From: Matthew Chadwick
Sent: 30 June 2020 13:29
To: DC Support
Subject: FW: 20/01316/TEL56 - Land West Of Buildings 138 & 139 Bicester Heritage Adjacent To Skimmingdish Lane, Launton

Planning application:	20/01316/TEL56
Location:	Land West Of Buildings 138 & 139 Bicester Heritage Adjacent To Skimmingdish Lane, Launton
Description:	Street works style base station - the installation of a 17-metre phase 8 pole with wrap around cabinet built around the base, 3 no. new equipment cabinets and ancillary development thereto.

Title: 215 PROPOSED SITE PLAN

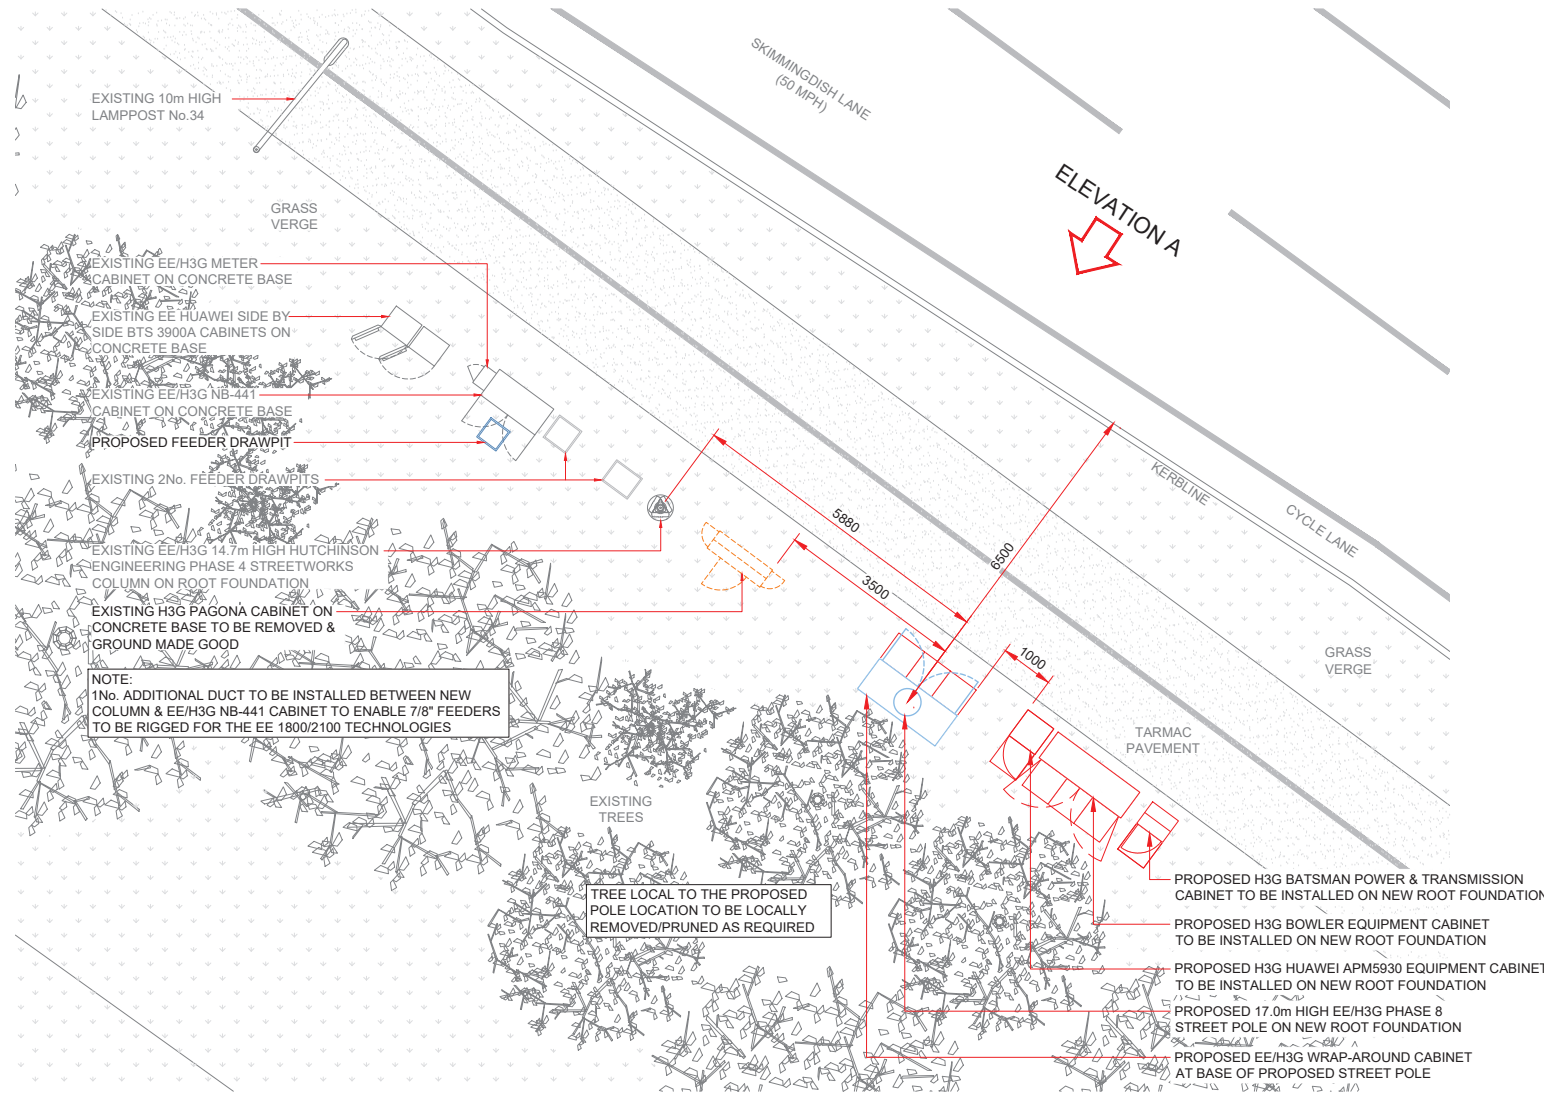
In order to carry out the installation of the equipment proposed, it is likely that a section of Skimmingdish Lane including the adjacent shared pedestrian/cyclist facility shall need to be temporarily closed to enable such works to be erected. This would require a combination of temporary traffic management, road closure, footway closure and occupation of the highway licences to be obtained via the link below;

Oxfordshire County Council, as the Local Highways Authority, hereby notify the District Planning Authority that they **do not object** to the granting of planning permission., subject to acquiring the necessary licensing required for the installations to be carried out in a safe environment.
